REFERENCE: Traffic Circulation Layout Plan and Grading and Drainage Plan for Tract A-2, at 300 Aspen Avenue NW, (J14-D145)

This letter is in response to the Transportation Section letter of September 27, 2005, and the Hydrology Section letter of September 26, 2005, both letters referring to my letters of September 23, 2005 on the certification of the of the referenced plans.

On October 6, 2005 the Los Pinos representative, Steve Montgomery and myself met with Nilo E. Salgado-Fernandez and Phillip Lovato, representing the Hydrology Section. The purpose of the meeting on-site at 300 Aspen NW was to determine existing construction deficiencies and recommend corrections.

DRAINAGE AND GRADING PLAN FOR ASPEN/3RD STREET BUILDINGS 300 ASPEN AVENUE N.W.

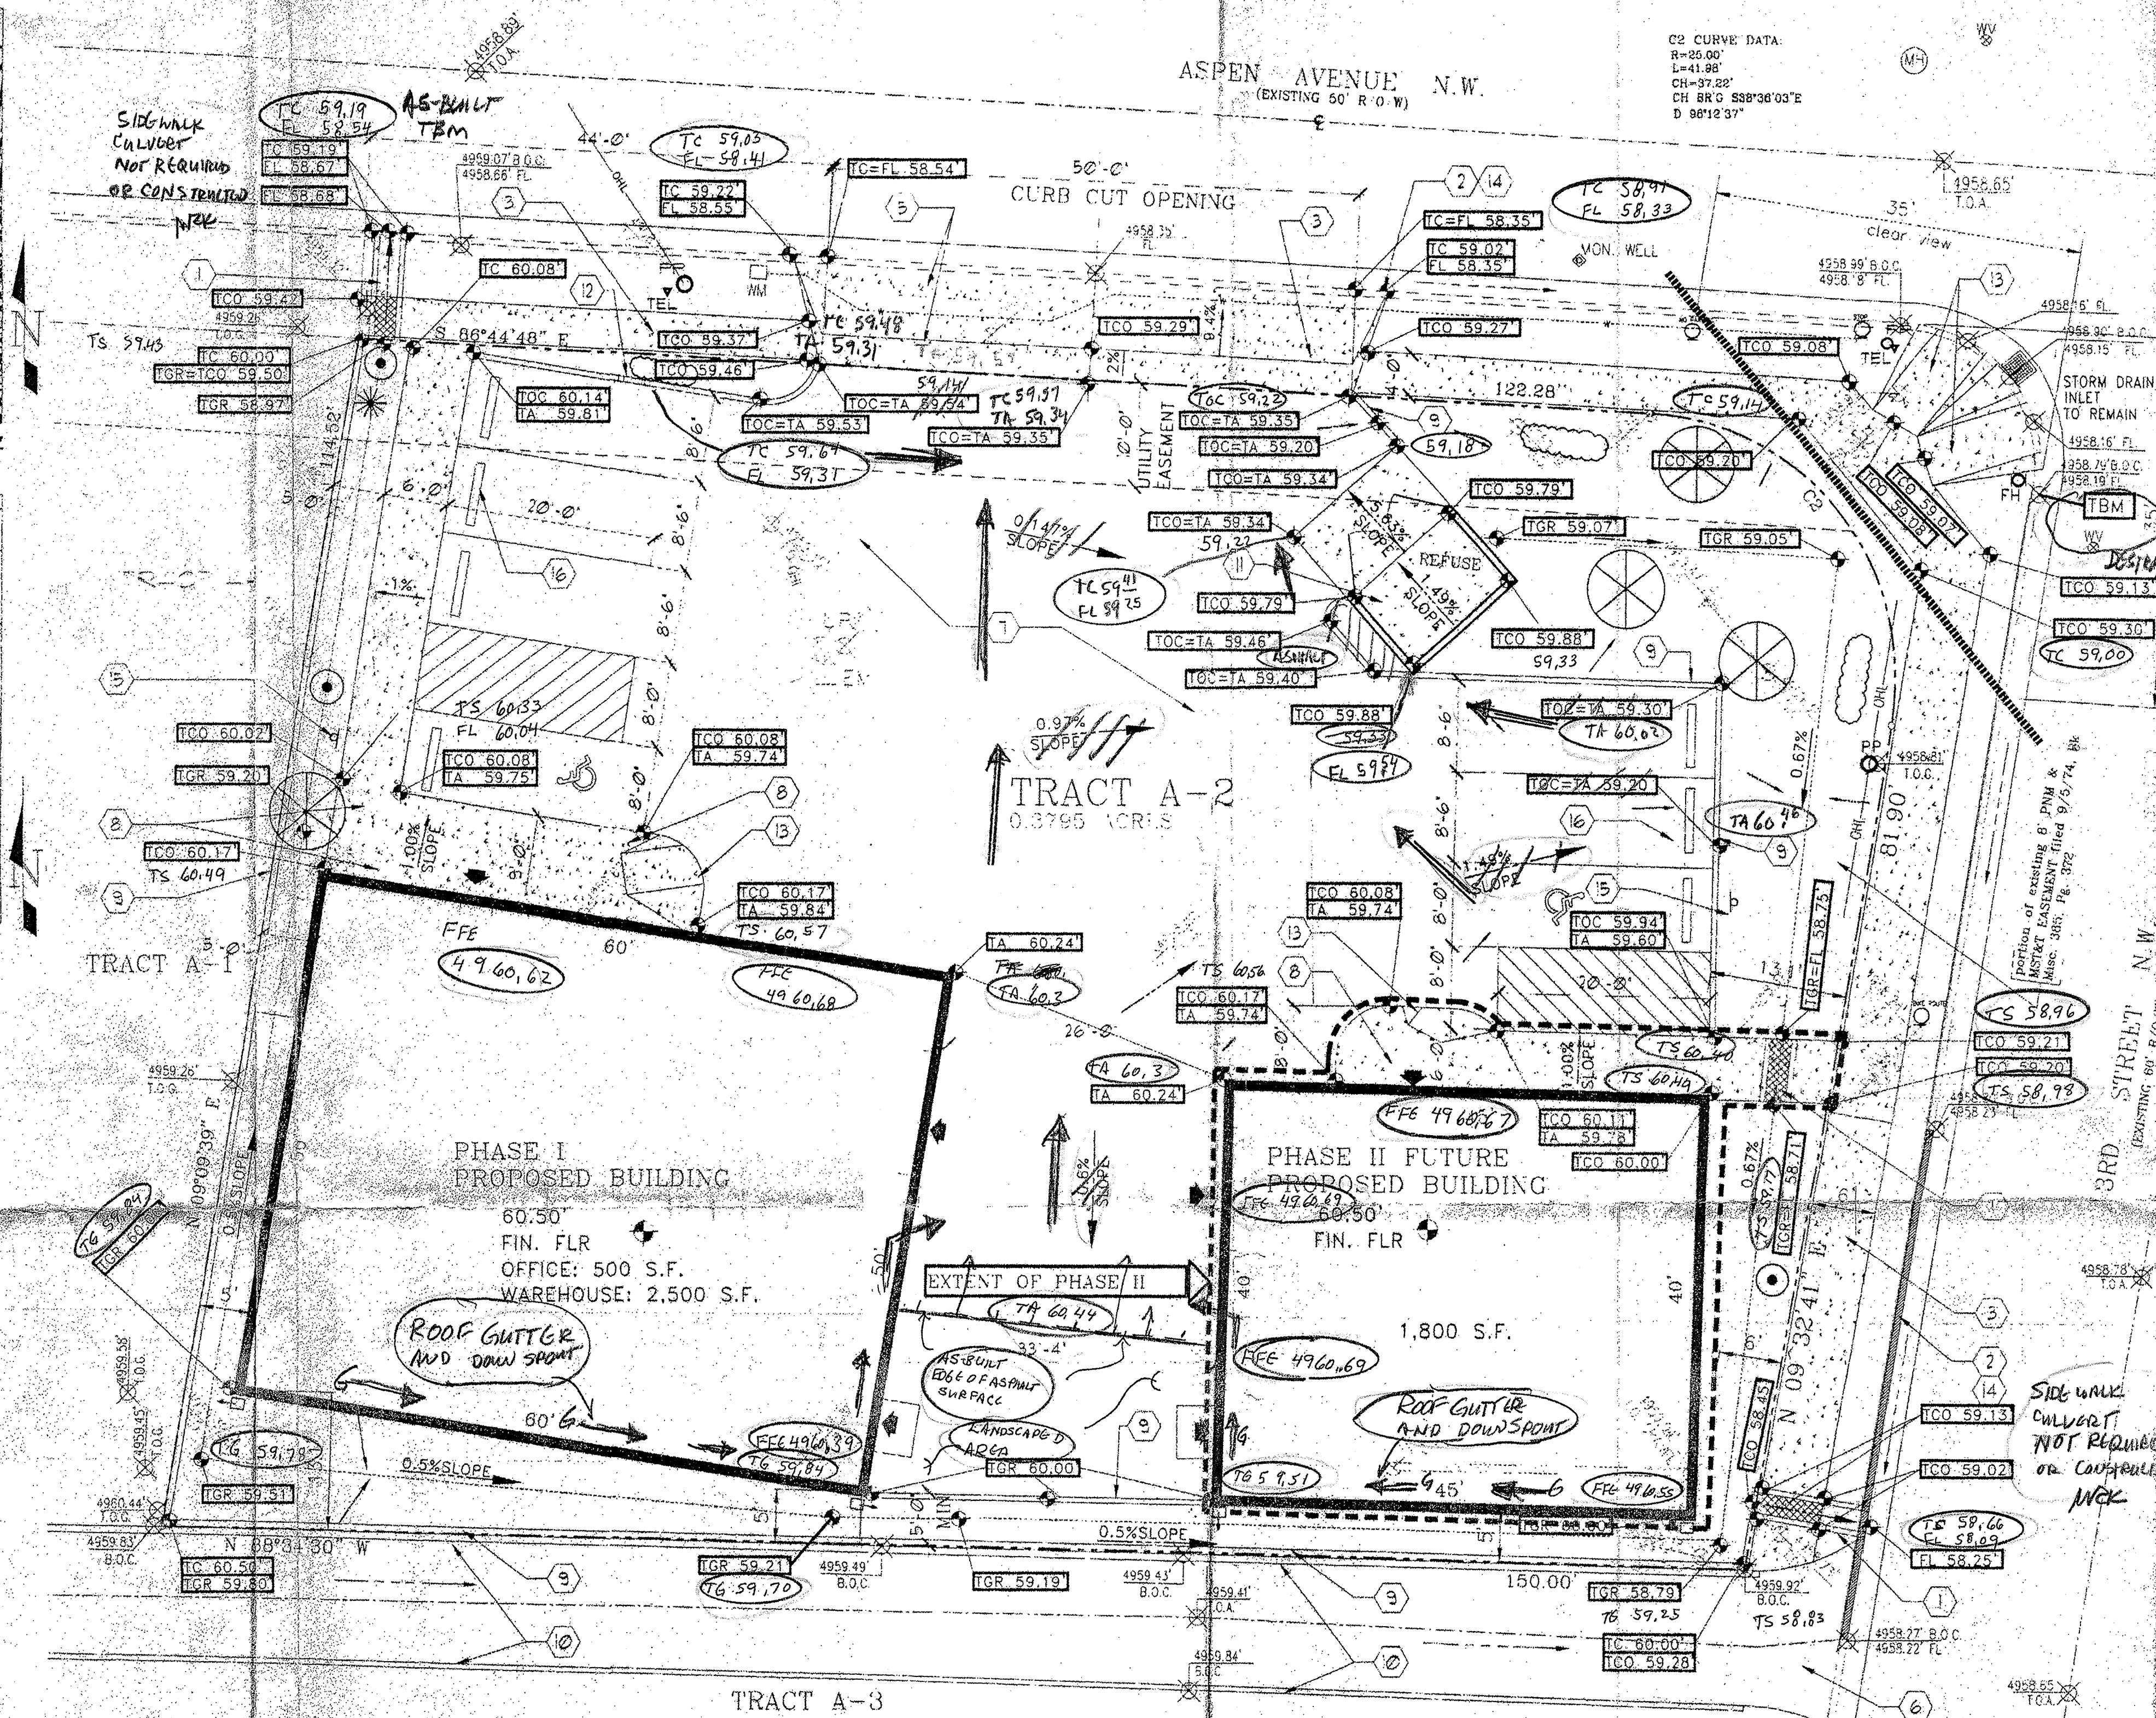
1. The sidewalk culvert on the southeast corner of the property (3<sup>rd</sup> Street) and the sidewalk culvert on the northwest corner (Aspen Avenue) are not constructed.

4. The asphalt pavement along the east side drains to the landscaped area in the northeast corner of the property (this is generally according to the approved G & D plan). The landscaped area has settled along the property line on Aspen, which is causing an undercutting of the sidewalk

5. The asphalt surface of the parking area on the northern part of the property (along Aspen Avenue) is settling or was placed at too low of an elevation to drain over the driveway onto Aspen Avenue.

6. The concrete curb along the south and west side of the property has not been constructed.

1. The sidewalk culverts will be deleted as a requirement when the remedial actions stated in the following paragraphs are completed.
2. The hole and trench along the northwest corner will be filled and compacted.

4. The landscaped area along Aspen Avenue in the northeast corner of the property will be raised to a surface elevation level about 1 inch below the sidewalk top surface, then sloping into the landscaped area to have runoff enter the landscaped area. The width of this part of the landscaped area that is higher than the rest of the landscaped area will be about 5 feet to prevent water standing against the sidewalk and undermining the sidewalk. It is noted that the approved plan was for this landscaped area to drain toward the sidewalk culvert in 3<sup>rd</sup> Street, near the southeast corner of the property. The overall shallow slope of the landscaped area and the street gutter along 3<sup>rd</sup> Street result in a surface that has a slope of less than 1 %, a slope too shallow for good runoff flow.

5. The depressed asphalt surface along the north part of the parking area will be paved with additional asphalt to insure that surface runoff from the asphalt surface will flow over the driveway and into the gutter along Aspen Avenue. There is sufficient drop from the building floor elevation to the top of drivepad to obtain an adequate slope for runoff with no deep depressions (bird baths).

6. The curb along the south and west side (and as necessary along the east side) will be constructed with treated timbers, 6" x 6" cross section, and to the height specified on the drawing, which is about the height of the finished concrete floors. The area between the building and the curb will be covered with landscape gravel to a depth of about 6 inches to absorb and hold the direct precipitation. The roof runoff to the south sides of the building will be caught in roof gutters, and downspouts to direct the roof runoff to the asphalt surface north of the buildings. At the time of the meeting on-site the roof gutters were being installed.

SHEET
AS-1

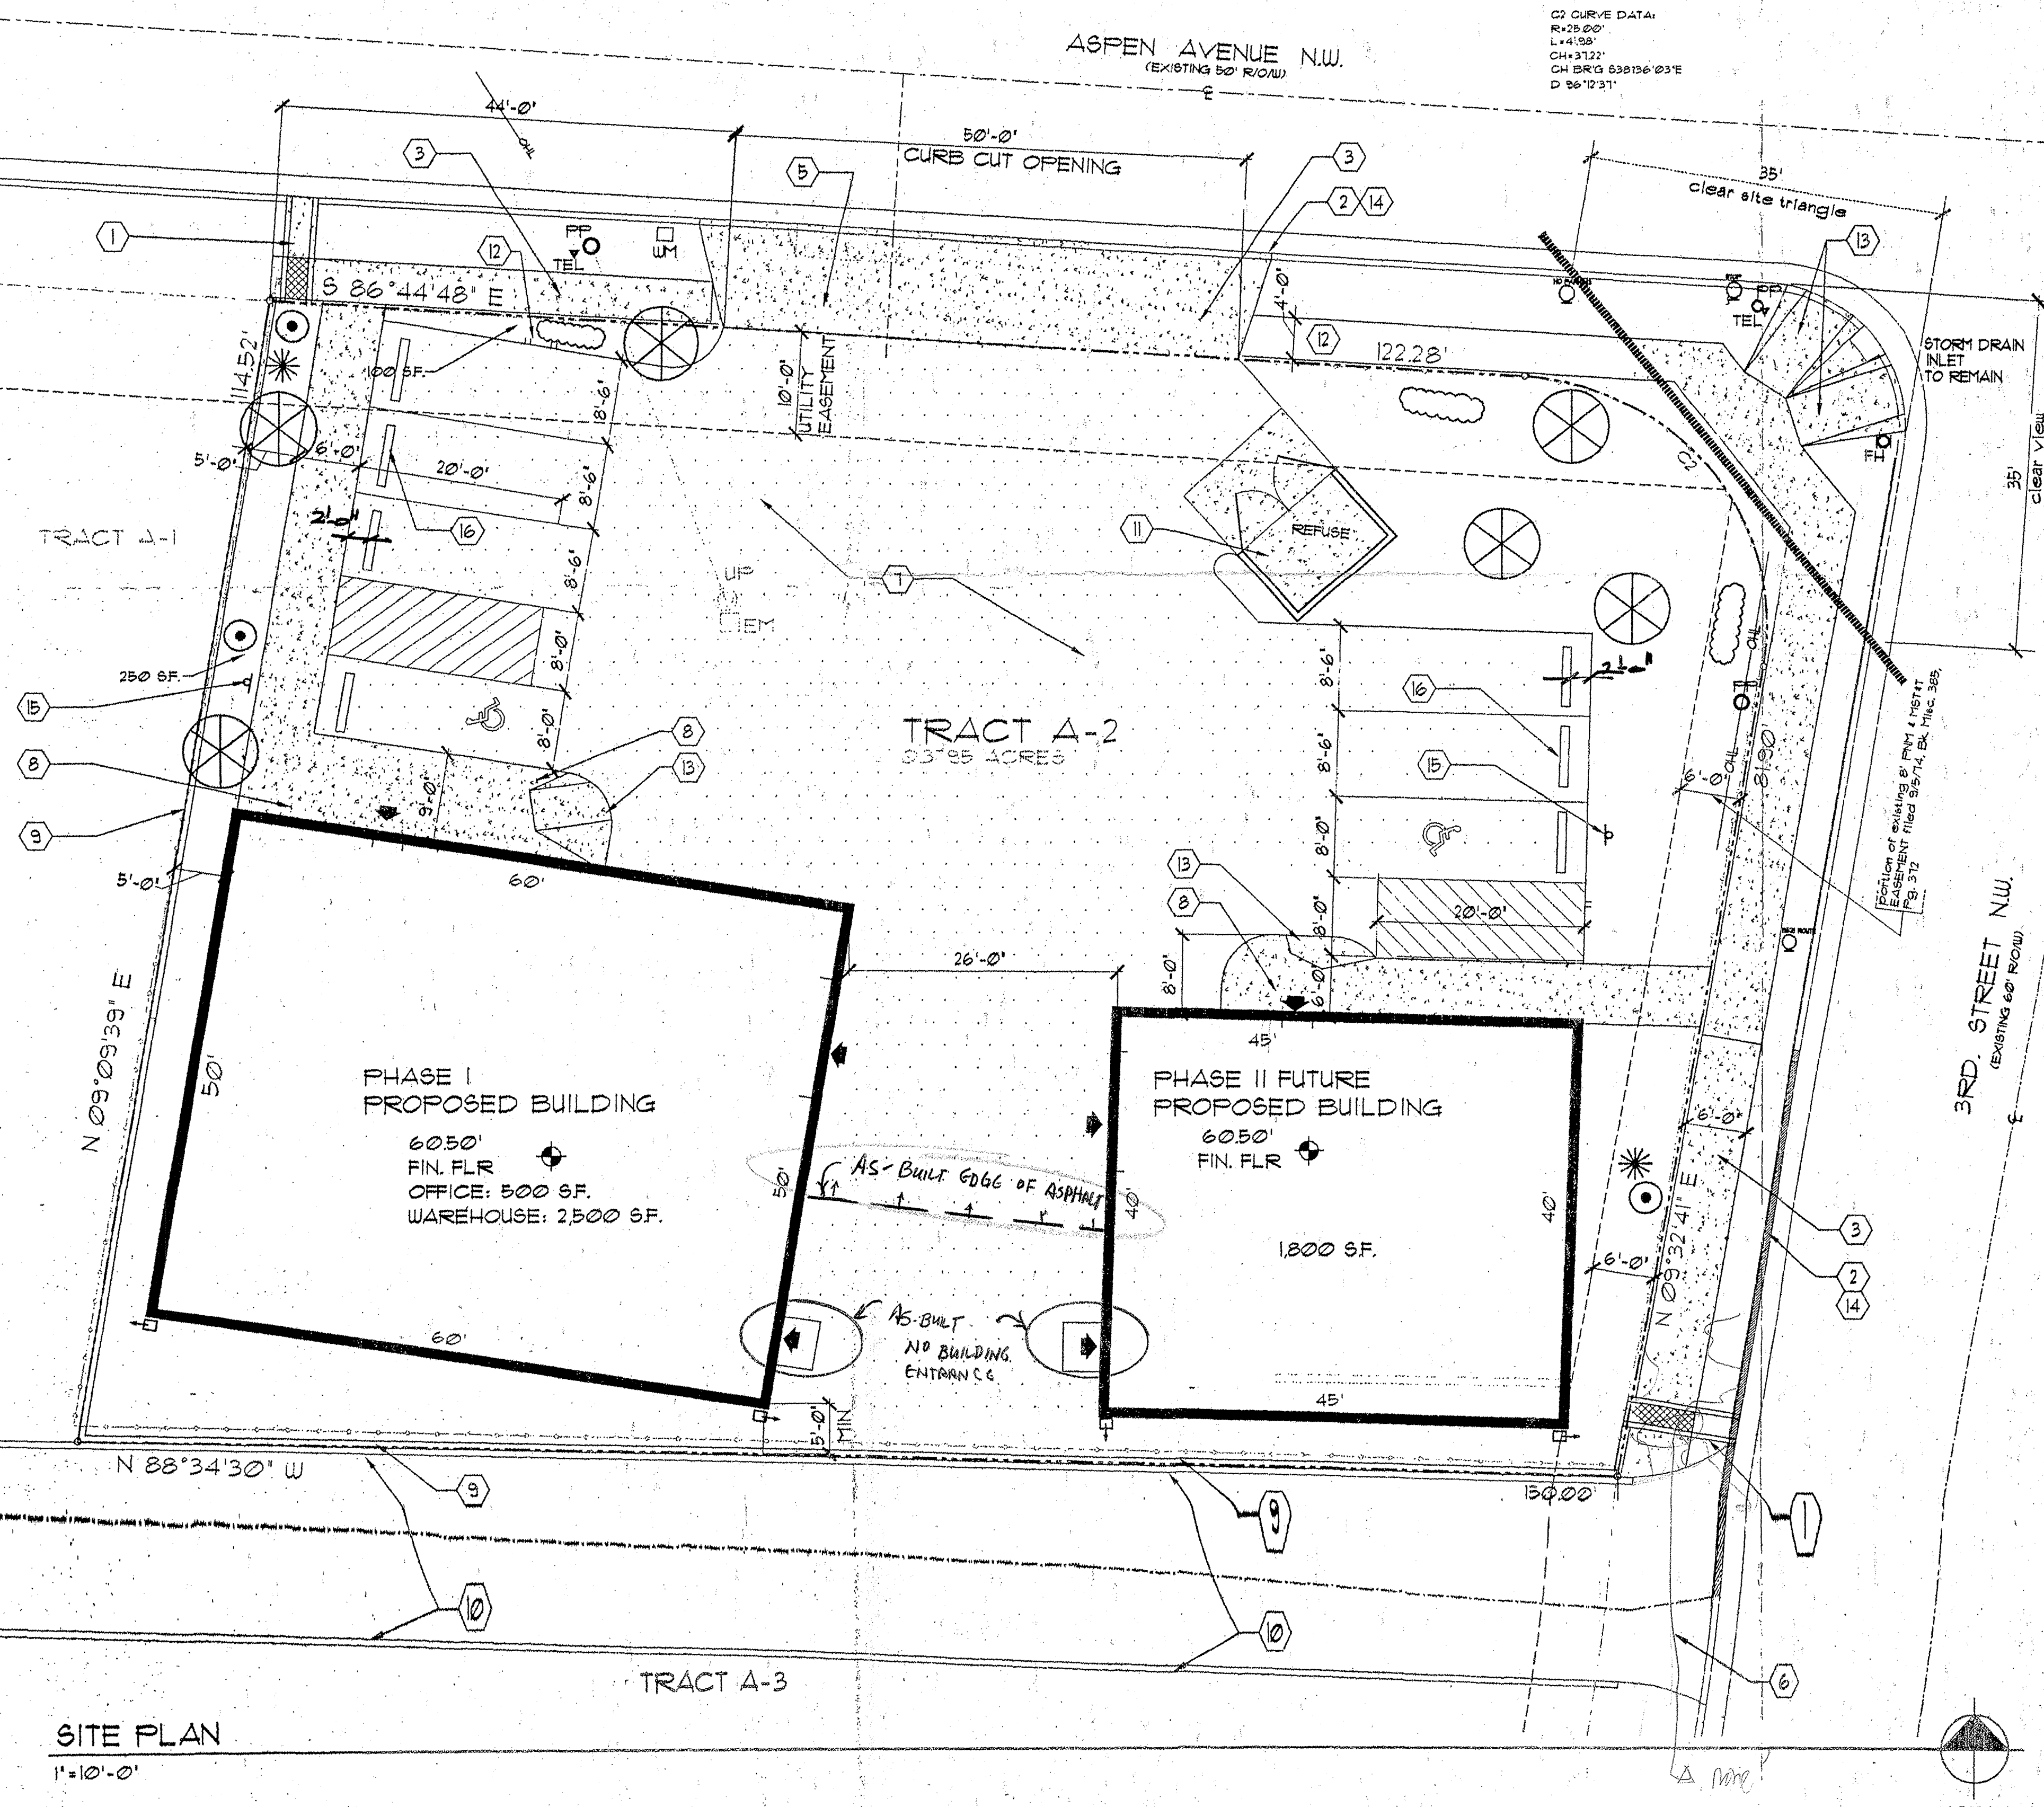
3. There are some sections of sidewalk near the southeast corner of the property that are cracked and settling, resulting in jutting edge of the adjacent driveway.

3. The broken sidewalk sections will be removed, the subgrade compacted according to the City of Albuquerque Standard Specifications for Public Works (95% for 12 inches below the sidewalk), and sidewalk sections constructed with a surface level with adjacent sidewalk and drivepad surfaces.

The certified drawings will show the as-constructed sidewalk widths, as well as the recommended corrections stated above.
